Planning Application No: 3/2026/0013

Proposal: Proposed change of use from dwelling house (Class C3) to residential children's home (Class C2) for up to 2 children aged 4-18.

Location: 2A Monks Drive Longridge PR3 3FR

BLOCK PLAN
EXISTING

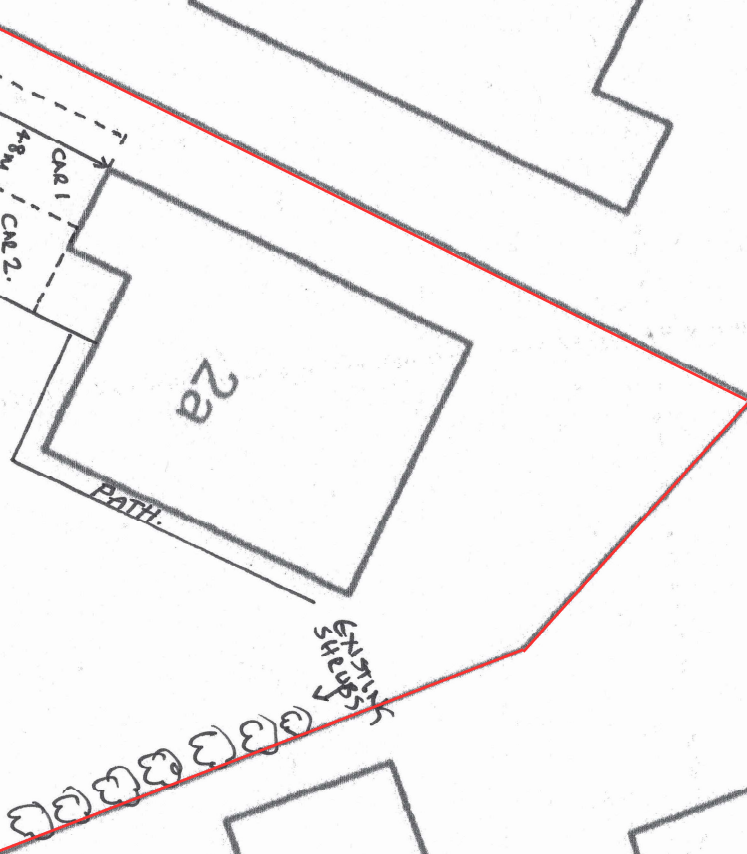
Our comments made for application no. 3.25.0910 remain regarding the length of the driveway space which must be a minimum of 4.8m long.
